App No: A/219/17/PL

Address: Land East of Windy Ridge Mayflower Way Angmering BN16 4AY

Proposal: 12No. Social dwellings for Angmering Community Land Trust,
including two communal bike stores, a pedestrian mews and orchard.
Departure from the Development Plan.

Figure 1: Phase 1 Survey Results

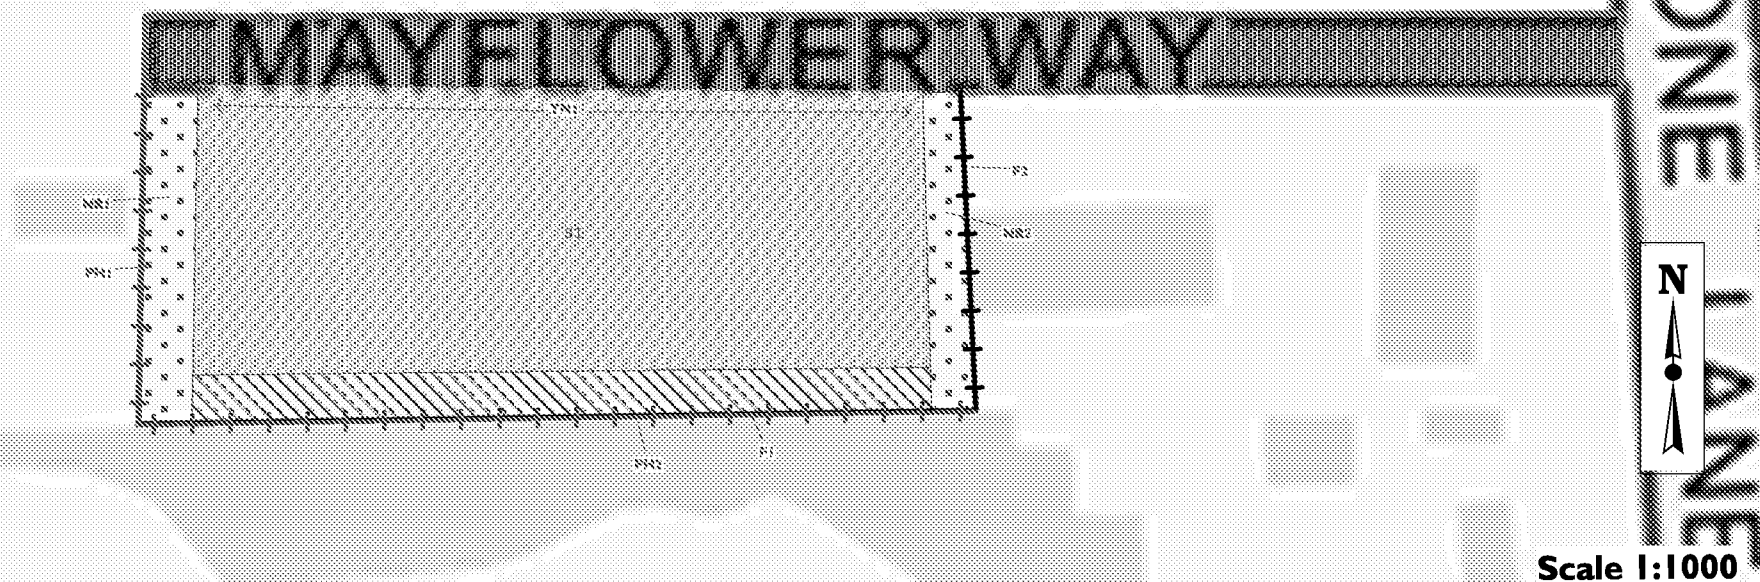
As detailed within the Preliminary ecological appraisal (Feb 2018) we require that a habitat suitability index assessment is done for great crested newts and following this any further presence and absence surveys as required.

The hedgerows on site are used by bats for commuting and foraging and will need to be retained and enhanced for bats. This will include having a buffer strip around the hedgerows (5m) and during construction fencing should be used to ensure this area is undisturbed. Any gaps should also be filled in using native hedge species to improve connectivity. Where any hedge is to be removed as detailed within the survey, new hedgerow should be planted. Conditions should be used to ensure this.
